Application by Orsted Hornsea Project Three (UK) Ltd for an Order granting Development Consent for the proposed Hornsea Project Three Offshore Wind Farm

The Examining Authority's Written Questions and Requests for Information

Issued on 9 October 2018

Figure 3.1: Pink-footed goose abundance and distribution October 2016 – March 2017.

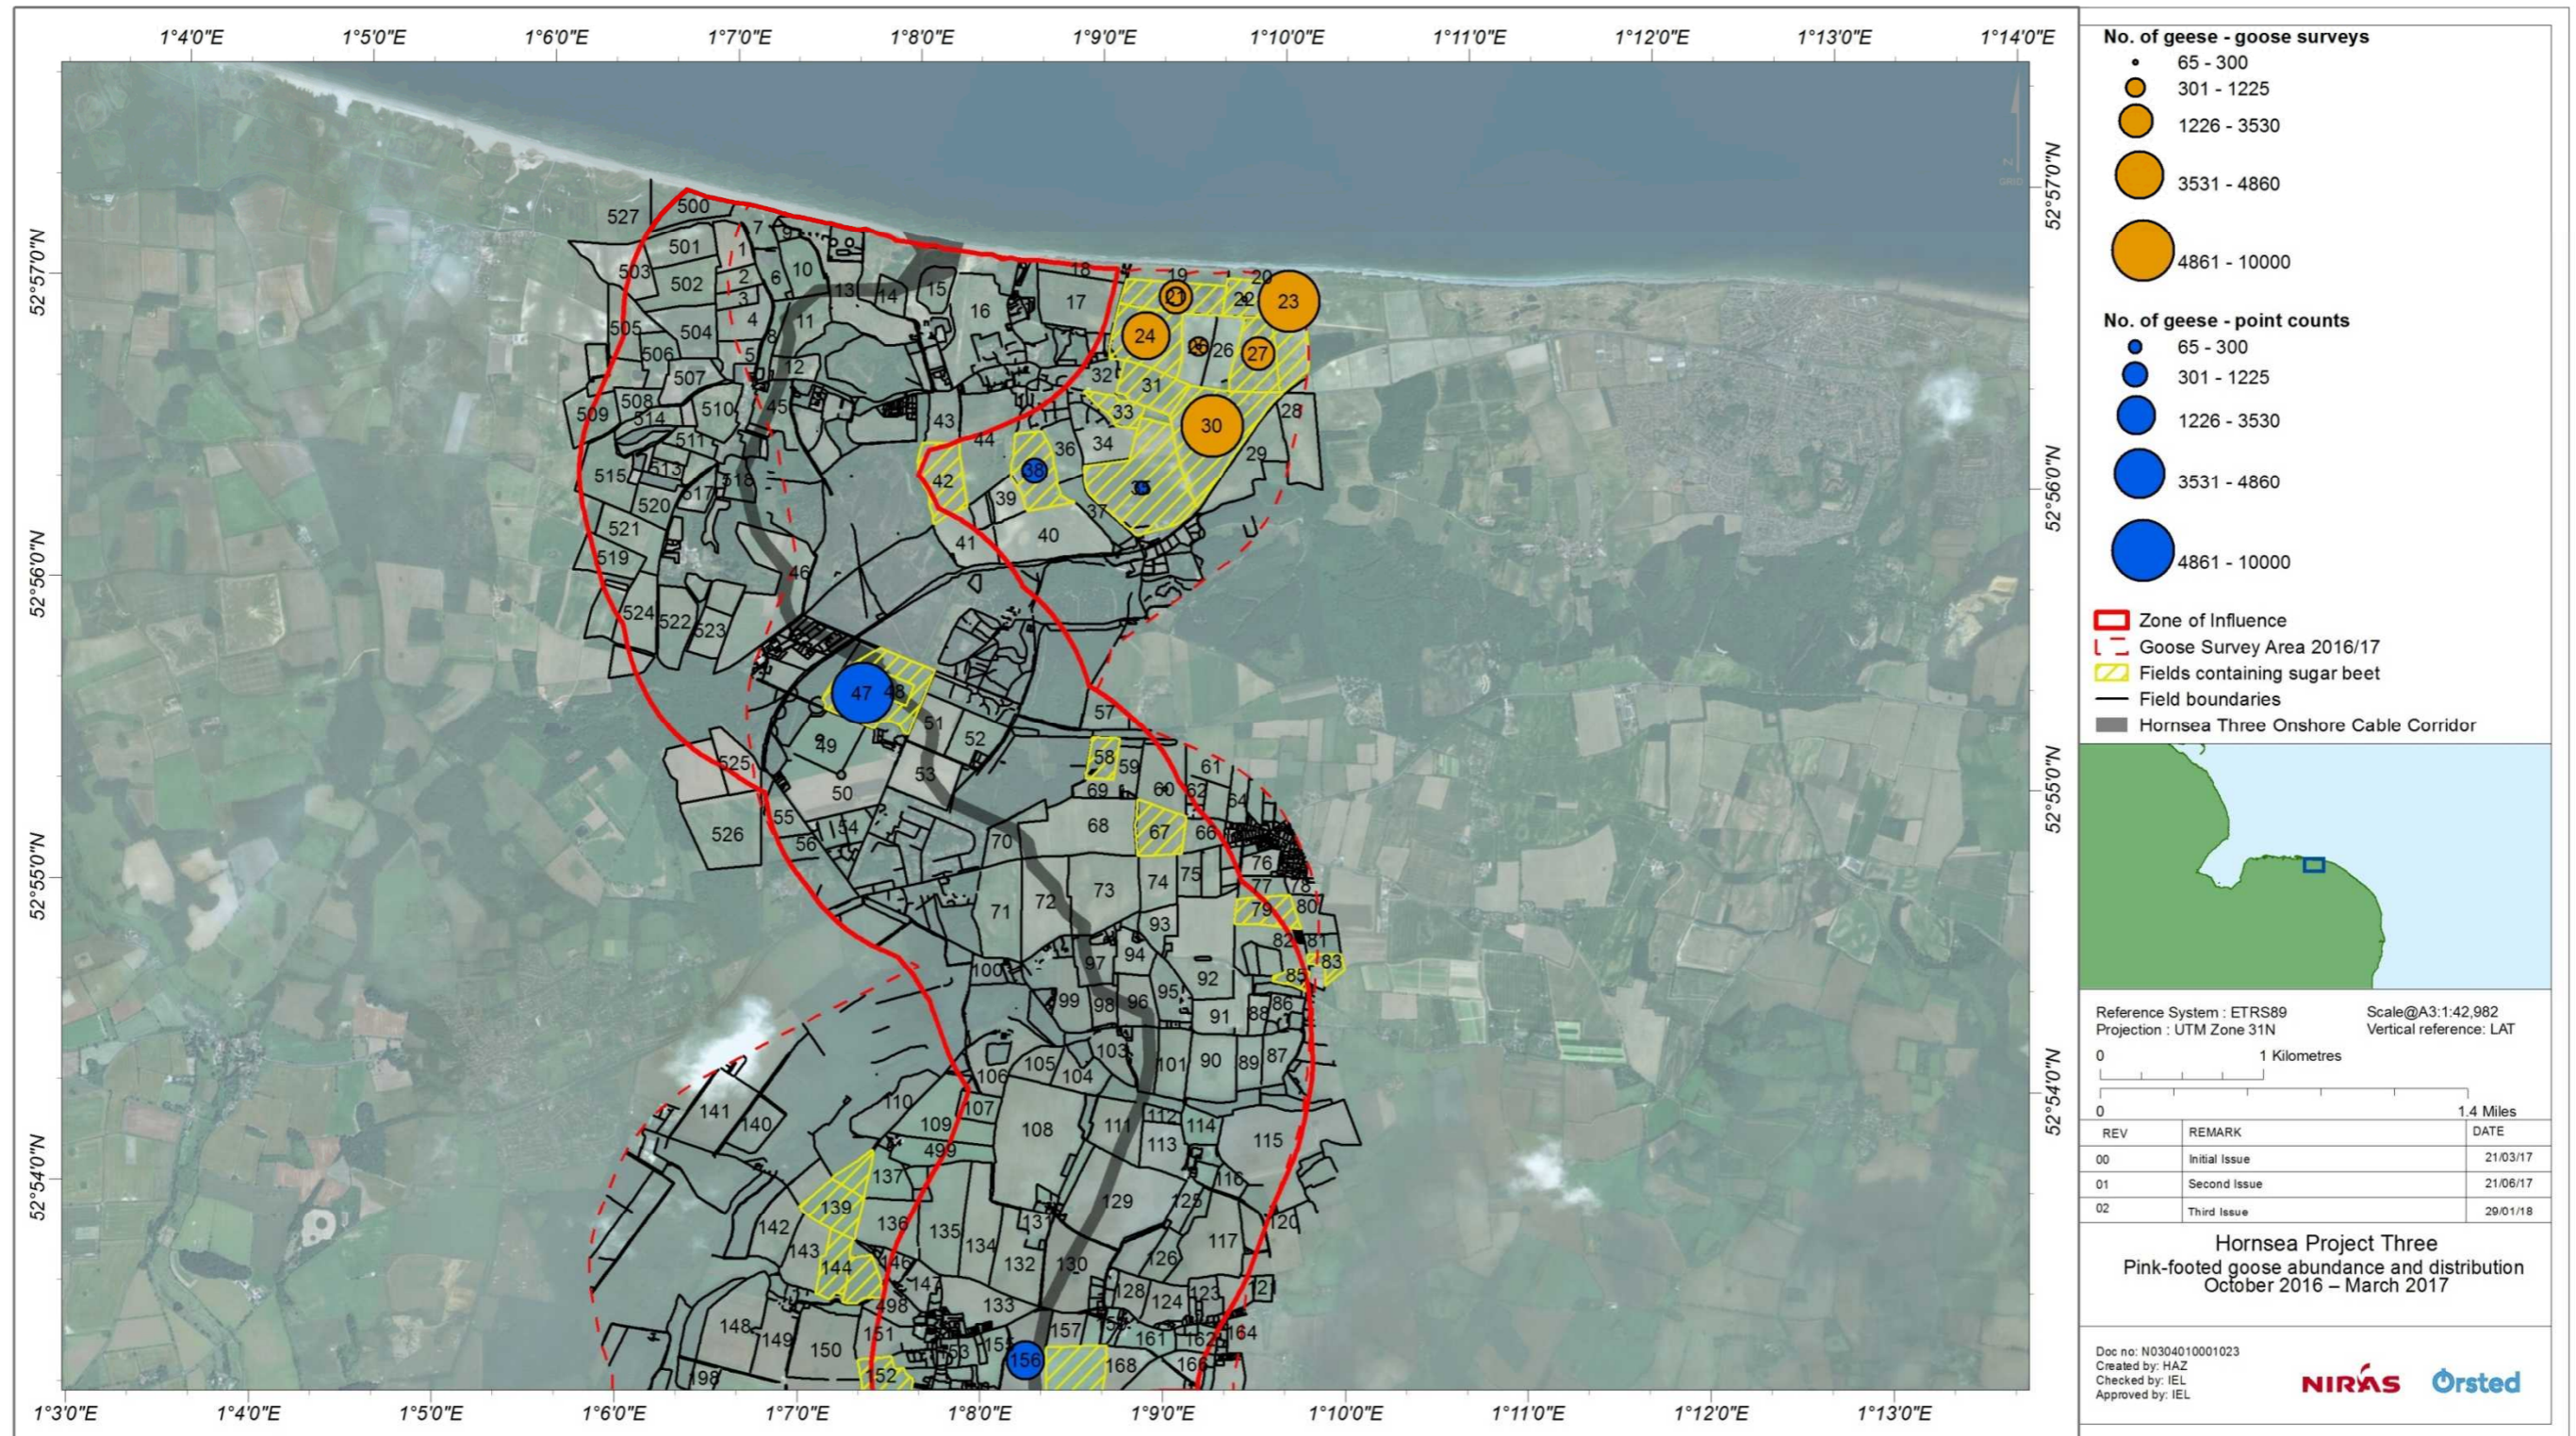
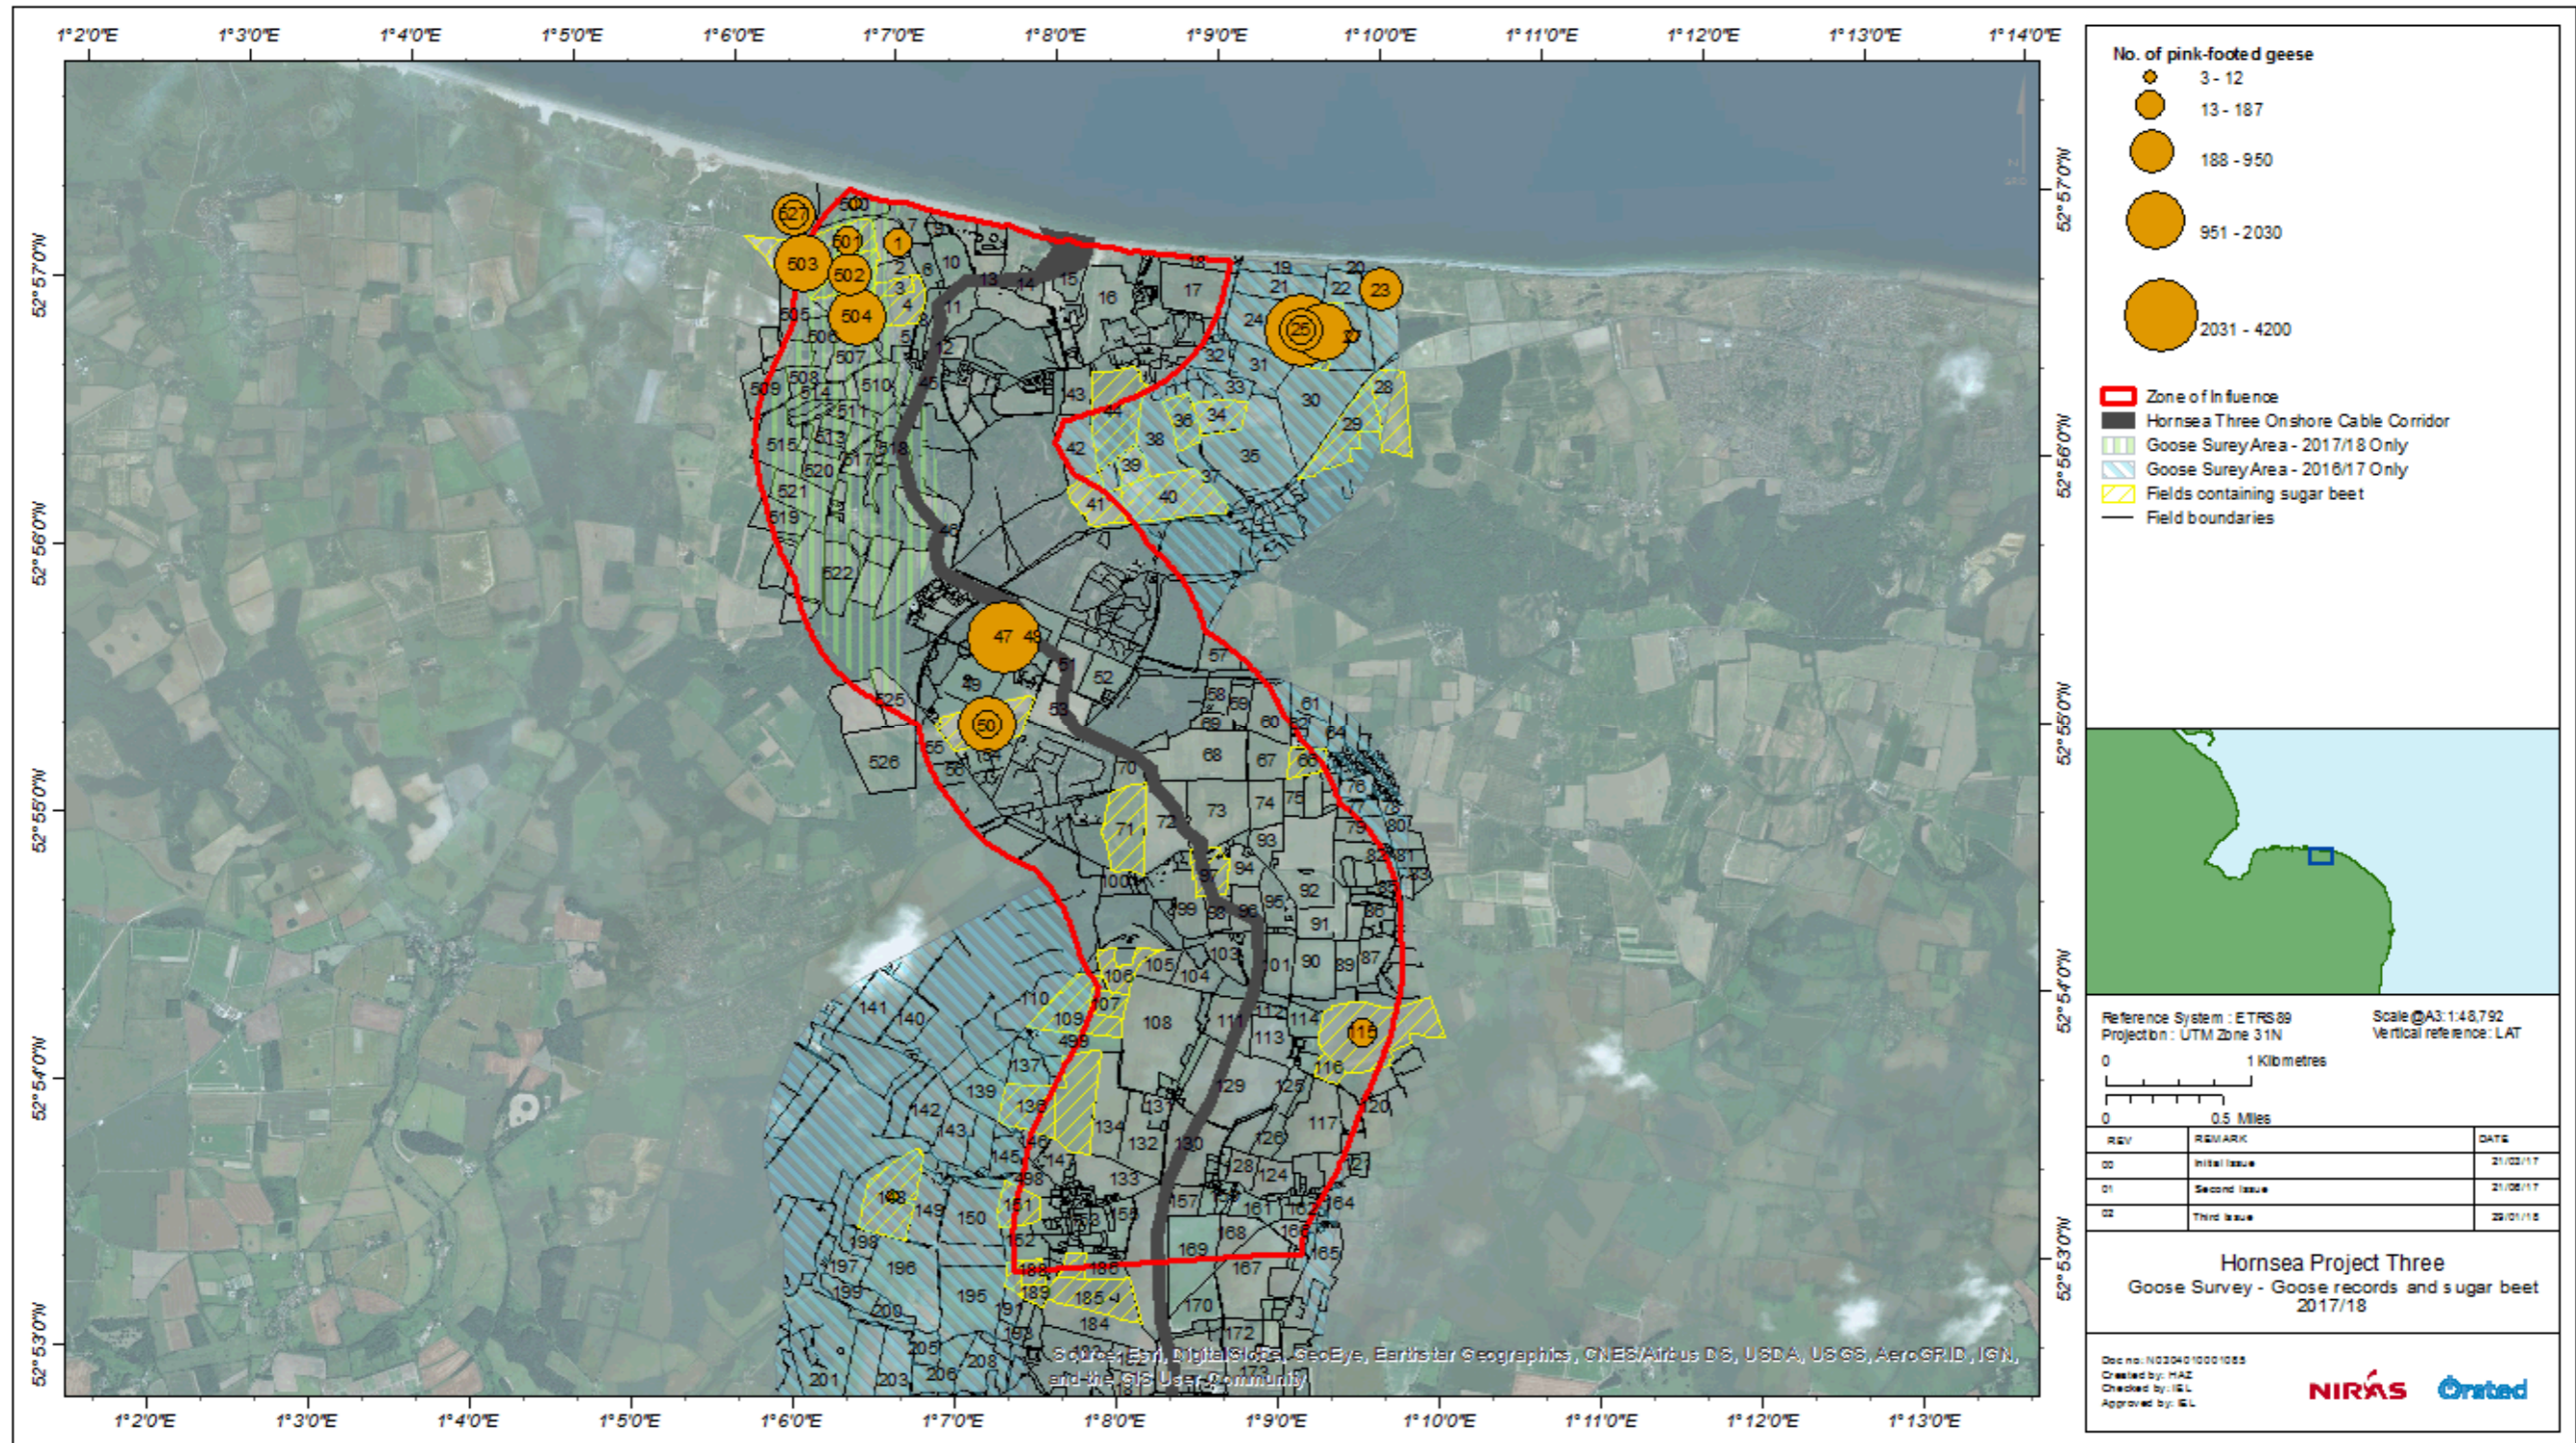
<p>sugar beet fields in this area are functionally linked habitat (paragraph 8.7.2.7, Report to Inform Appropriate Assessment).</p> <p>Figures 3.1 and 3.2 of the Wintering and Migratory Birds Report (ES, Annex 3.9 – Onshore Ecology – Wintering and Migratory Birds) clearly illustrate the distribution of the birds on the cable corridor. These show that the distribution of the birds is clearly influenced by the cropping patterns within the cable corridor as far fewer birds were found in the cable corridor in the winter of 2016/17 (figure 3.1) when far fewer fields were planted with sugar beet crop than in the winter of 2017/18 (figure 3.2). It is also important to note that the sugar beet fields only become functionally linked following the harvesting of sugar beet (paragraph 8.7.2.5, Report to Inform Appropriate Assessment). The RSPB consider that if sugar beet crops are grown within the cable corridor during the cable installation works it is inevitable that there will be a conflict between the geese and the construction works when those crops are harvested. This is likely to manifest itself in the form of disturbance to the birds, with associated energetic costs from flights at times that they should have been feeding. Given the proportion of the North Norfolk Coast SPA that utilises these fields the RSPB consider that it is not possible to exclude the risk of an adverse effect on the integrity of the SPA, and that consequently mitigation measures will be necessary.</p> <p>Mitigation measures</p> <p>The mitigation measures proposed would involve providing alternative foraging habitat “if required” (second bullet point, paragraph A.1.1.1, OCOCP, and second bullet point, paragraph 5.4.3.1, OEMP). Given the information in the paragraph above, the RSPB considers that alternative foraging habitat in the form of coordinated sugar beet cropping will be required to ensure that the pink-footed geese population is not disturbed by the construction works. To achieve optimum effects for the applicant this would take the form of both avoiding planting of sugar beet crops in the fields through which the cable corridor will pass during the years in which it will be constructed and either the planting of sugar beet crops in fields away from the cable corridor, or retention of sugar beet residues for a 30-day period (i.e. not simply ploughing in residues immediately after harvest to ensure food resource remains available). These measures would aim to attract the pink-footed geese away from the construction works and consequently</p>
